PE TEAGUE, PE, PLLC
2705 Waterloo Court, Raleigh, NC 27613
(919)247-2572, peteague50@gmail.com

RE: Engineering - Plan Review and Structural Recommendations
MIKE SAYRE PLAN
Project No.: 23PT-0620A

Thank you for using PE Teague. The plans named Mike Sayre, dated Preliminary 3-30-23, Final 4-17-23 and Revision 5-26-23 by Advanced House Plans and the Roof truss layouts prepared by Longleaf Truss Co. Project SAYRE ; order # P23-05036 with truss data dated Jun 15 2023 were provided by Mr Sayre. The wind speed for the plans was for 115 MPH and the North Carolina State Residential Building Code (NCSRBC) requires 130 MPR. The walls were analyzed for 130 MPH wind loading and will require the following:

SHEET
2
OF
8

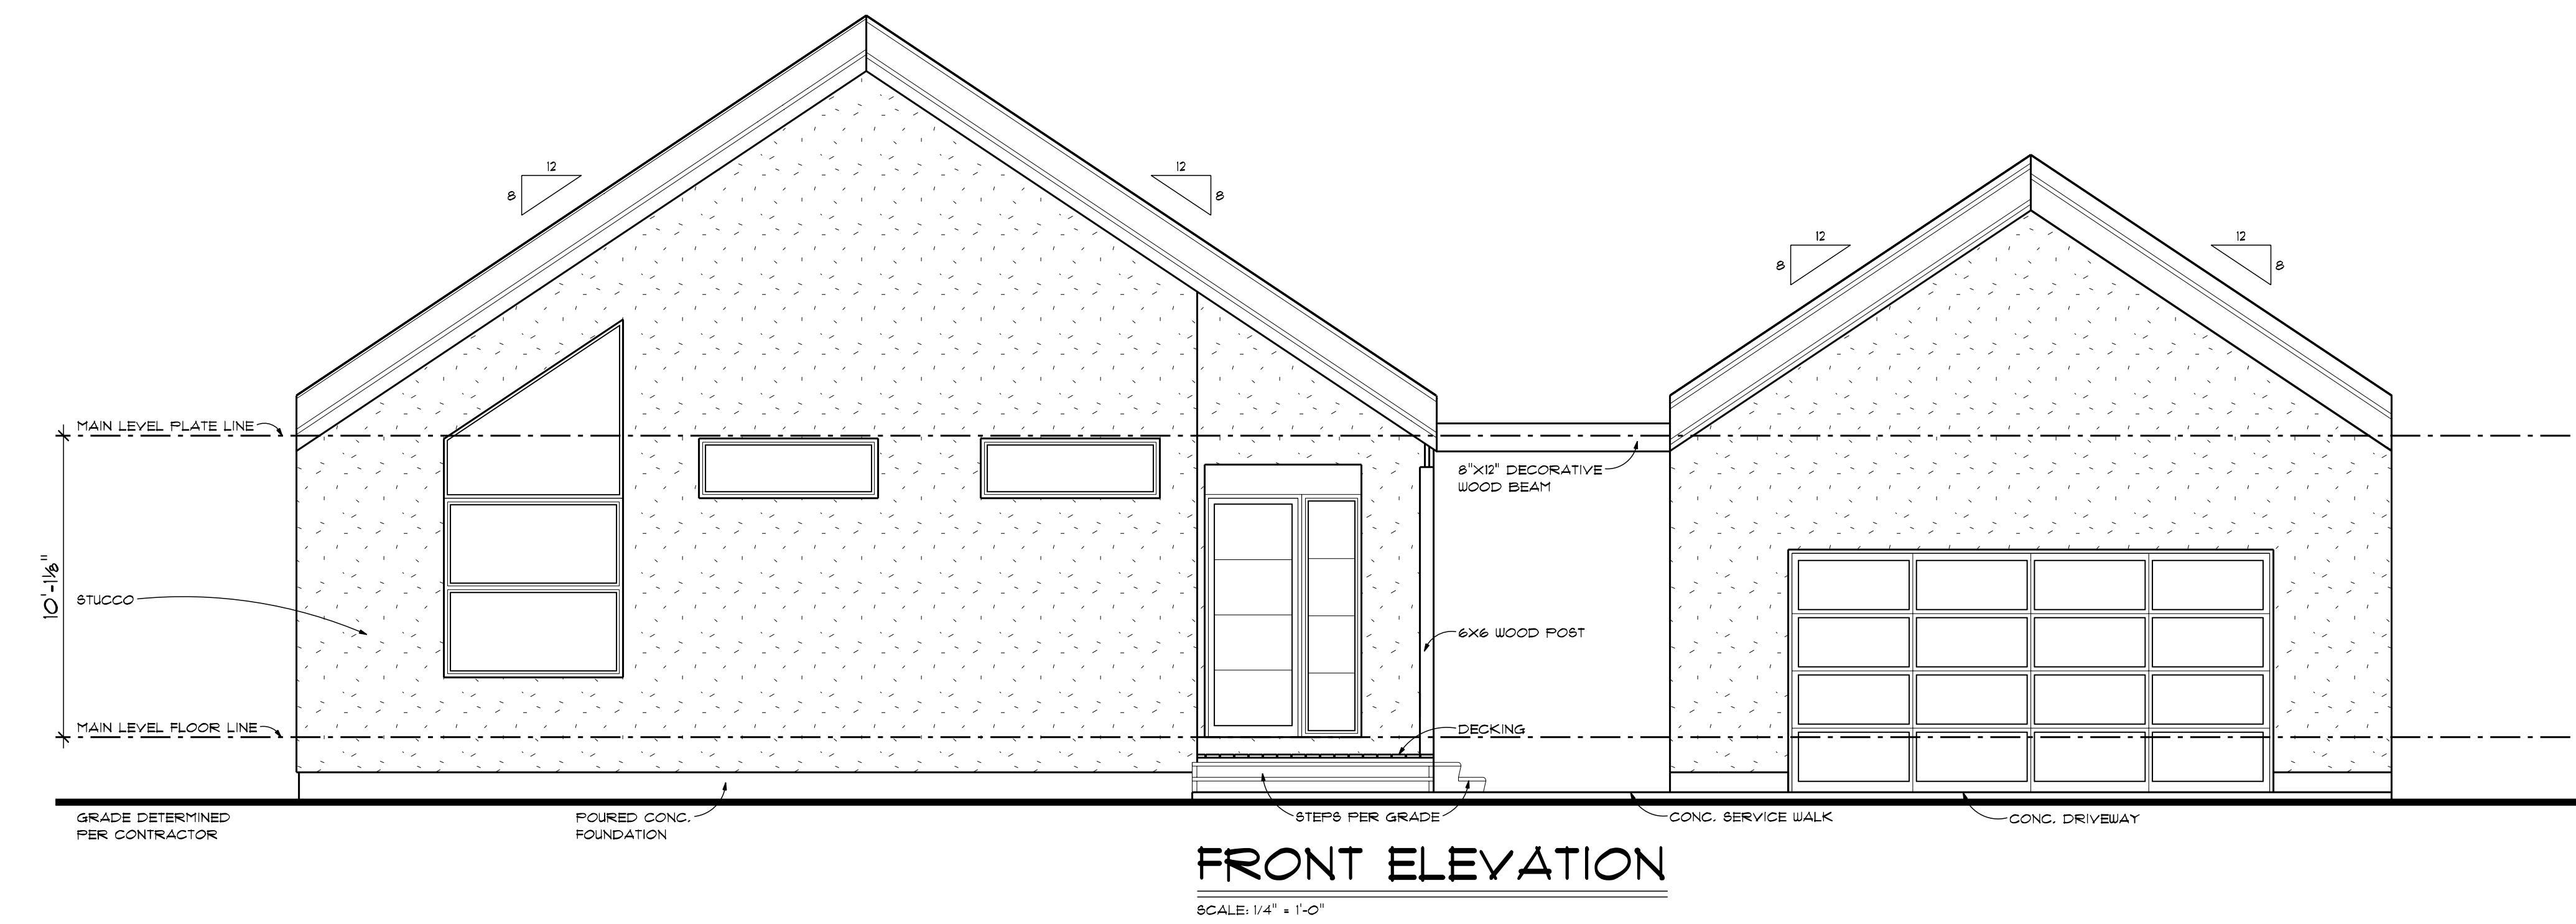
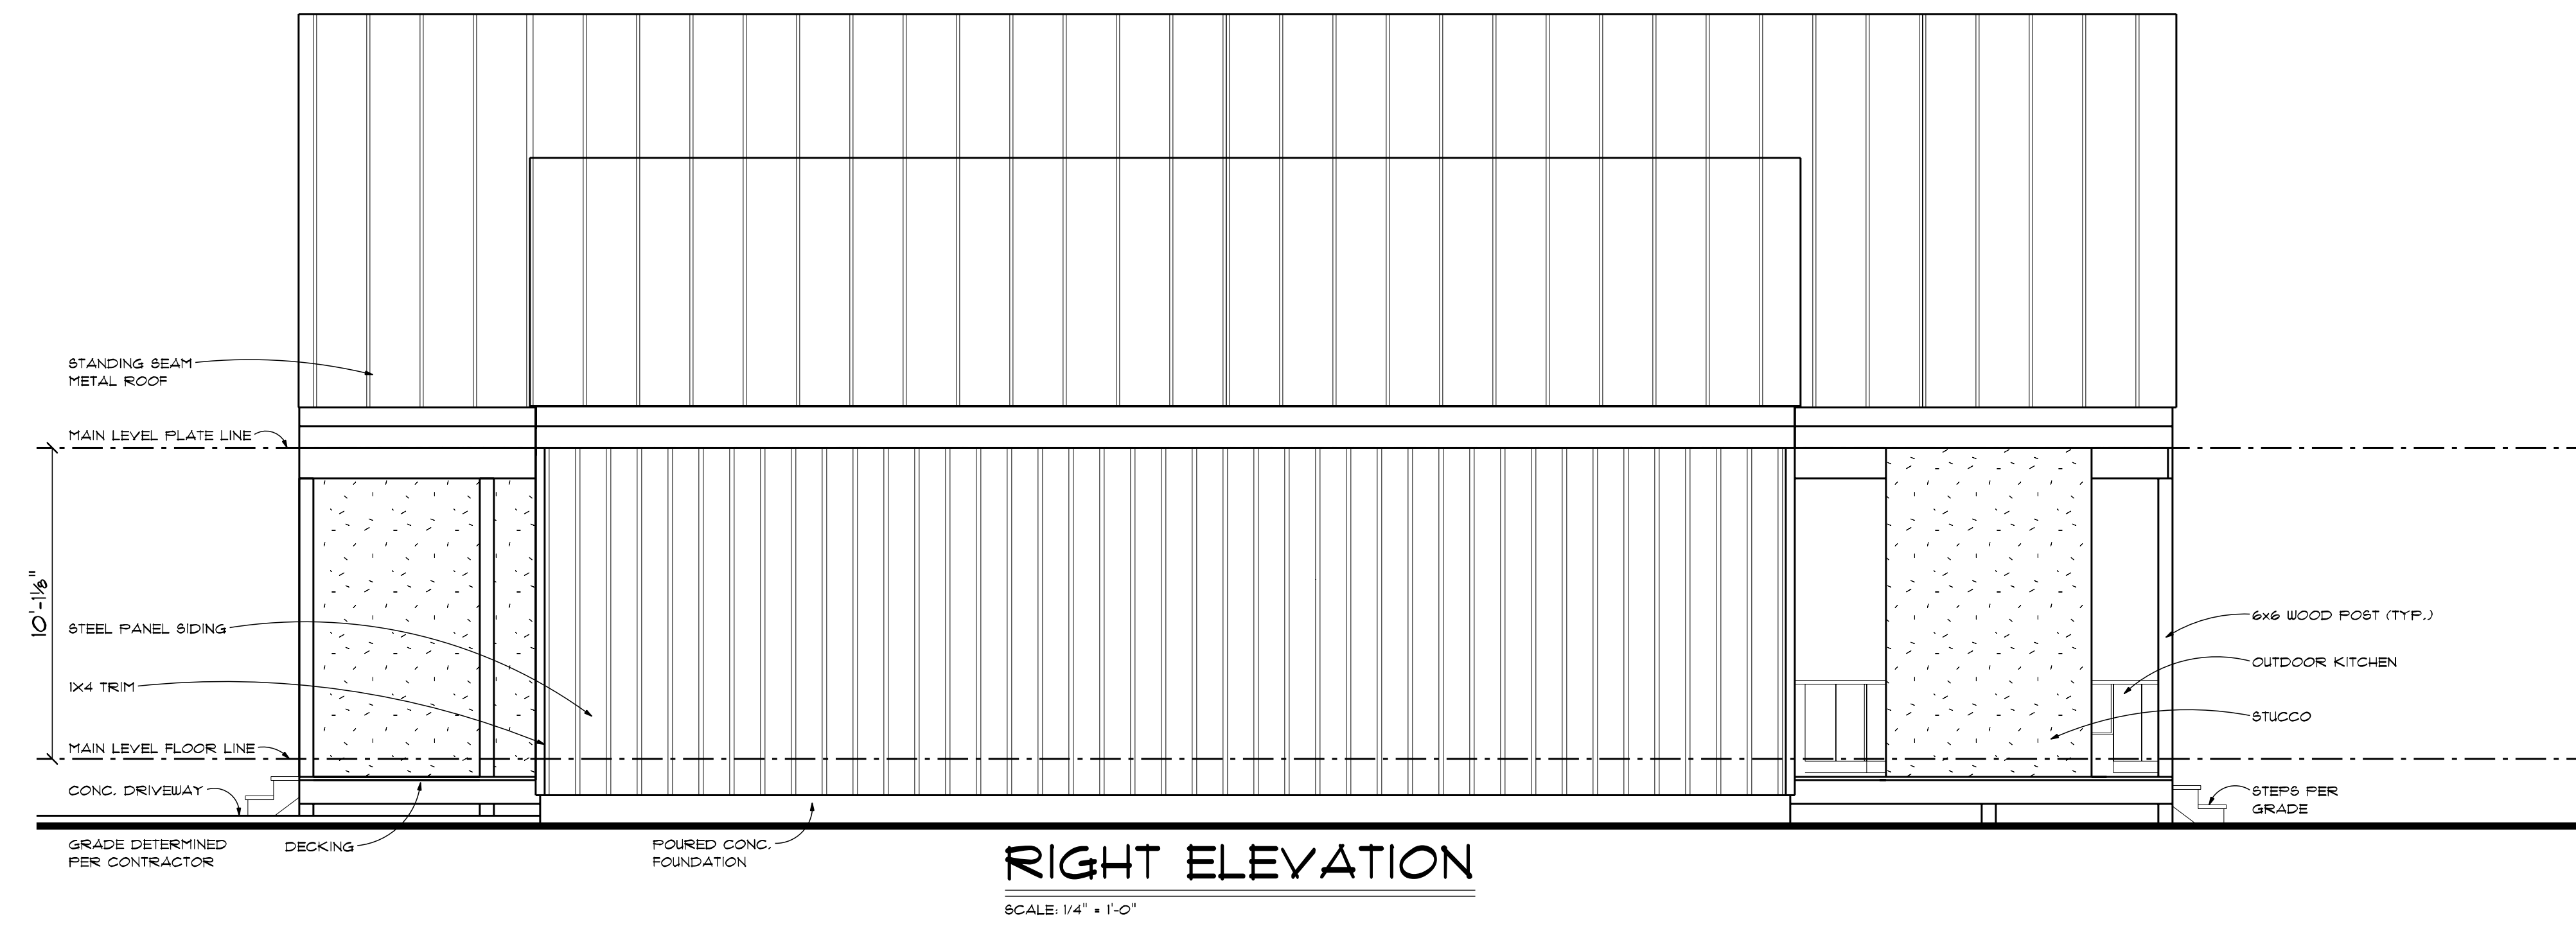
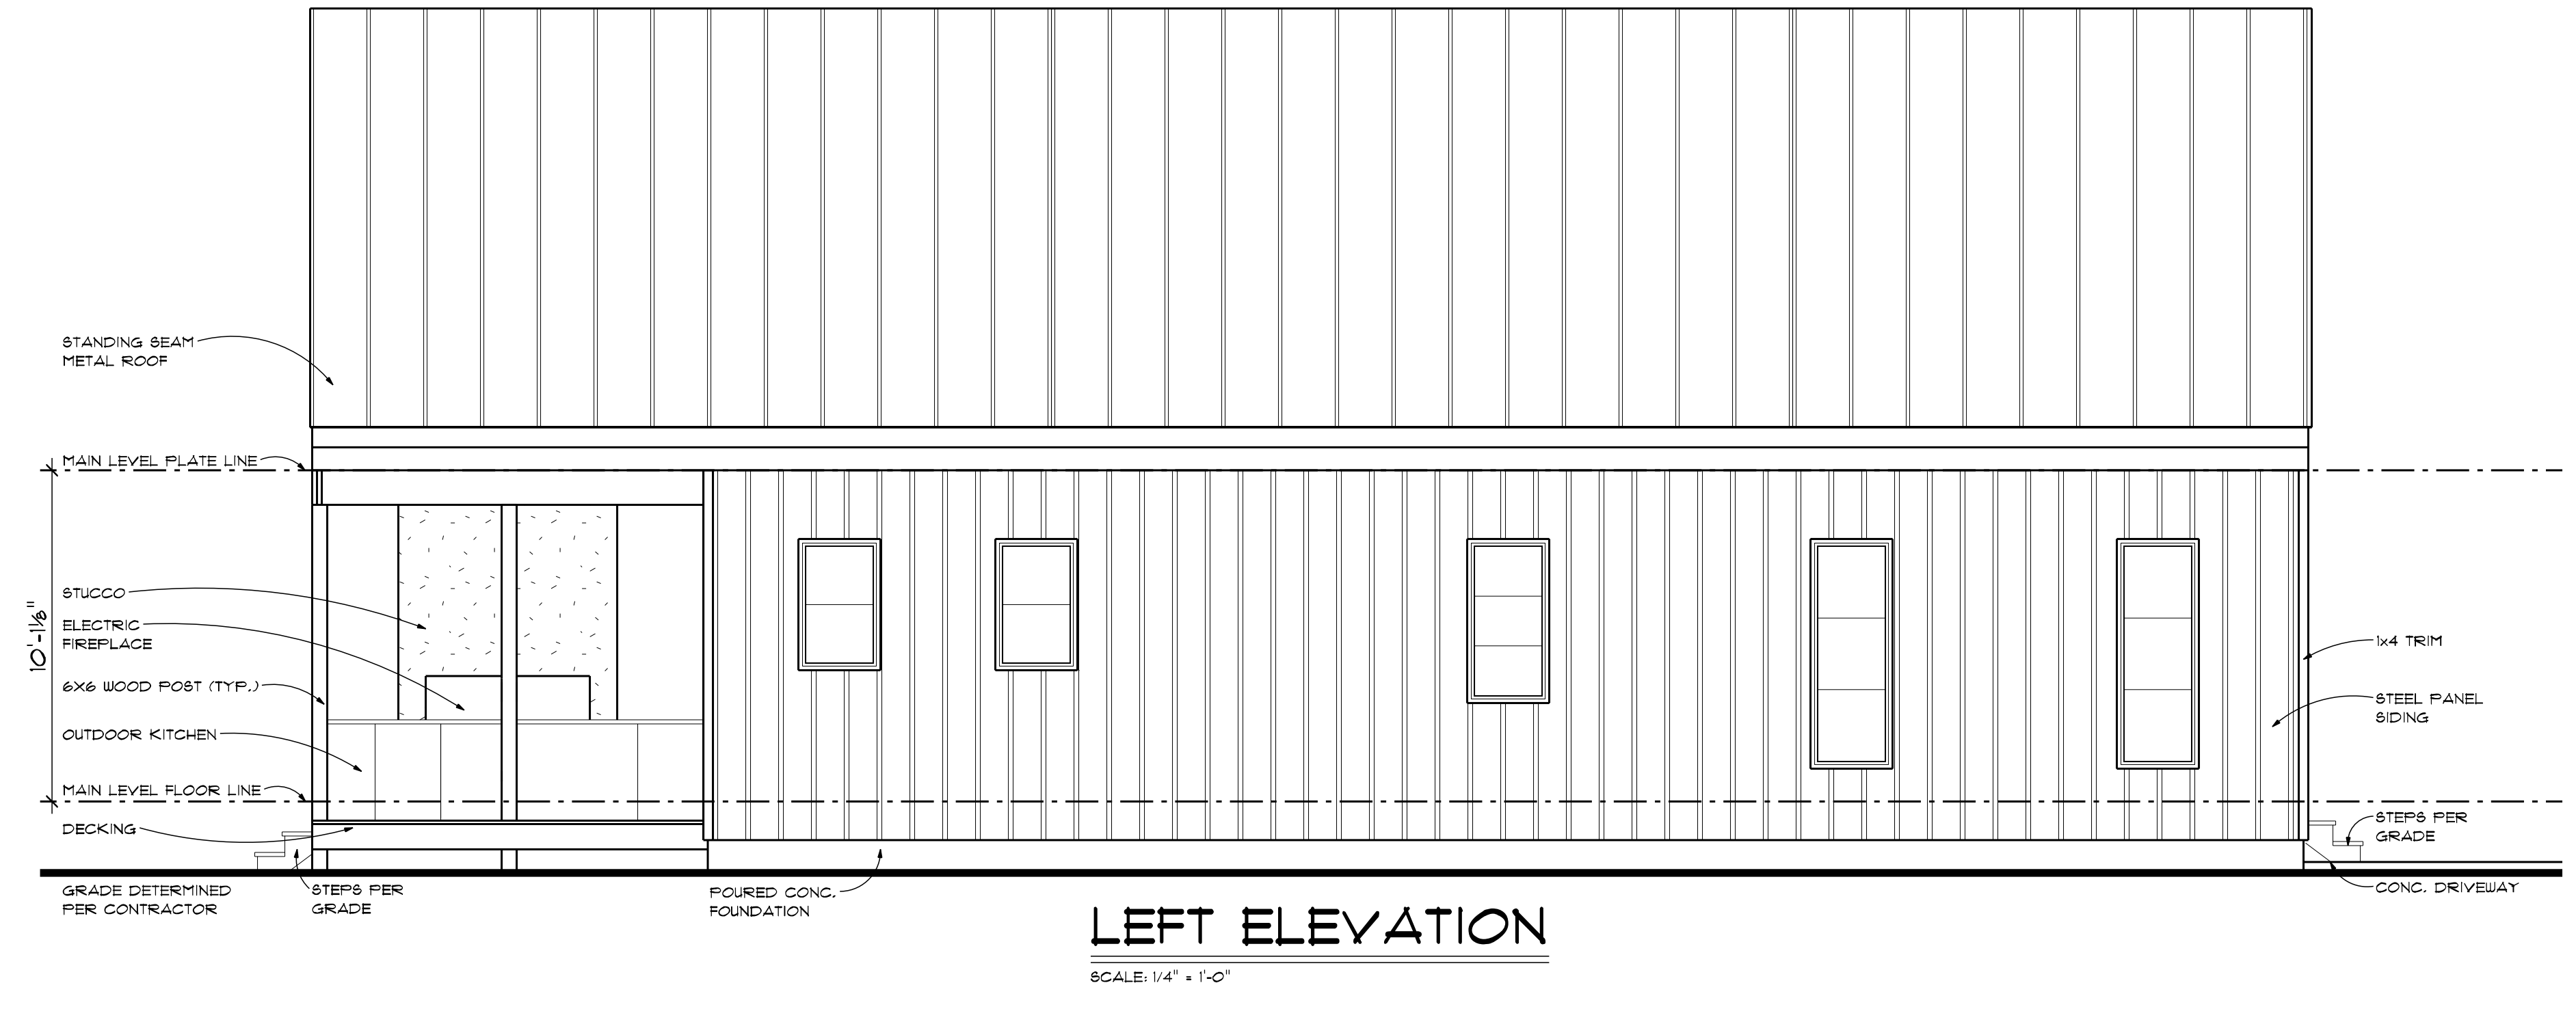
Brace walls for continuously structurally sheathed conditions are adequate with the following exceptions. The front garage wall and the rear wall for the main structure as shown on sheets 2 and 3 of 8 29955. These walls require portal framing in accordance with R602 of the NCSRBC. The headers across the walls should be (2)1.75X11-7/8 LVL's running across the entire walls in accordance with R602 of the NCSRBC. The walls will be required to have a Simpson H2.5 attached to the roof trusses to the top plate for the main structure as well as the rafters (use of conventional framing for the garage - changed from the roof trusses). The porch framing on the exterior require the beams to be treated SYP (4)2X12's spanning no greater than 7ft 2in in the clear and should be posted to a treated SYP 6X6 to be attached to the beams by a Simpson EPC6Z post cap and to the concrete footing by a Simpson ABA66Z post base. The posts should run from the bottom of the beam to the footing. This may require the floor bands to be through bolted to the posts with two 5/8" diameter bolts. The porch post footings will require a 18"x18"x18" concrete for each post. The foundation walls should have 8 inch CMU foundation walls on a 10" thick by 18" wide concrete footing with two # 4 reinforcing steel bars continuously. The walls should have 5/8" diameter foundation bolts 1 ft from each corner and every 6 ft c/c with the exception of the two portal frame walls outlined previously. The exterior porch bands and floor joists appear to be adequate for treated SYP framing members as shown on the plans as shown on sheets 4 and 5 of 8 22915.
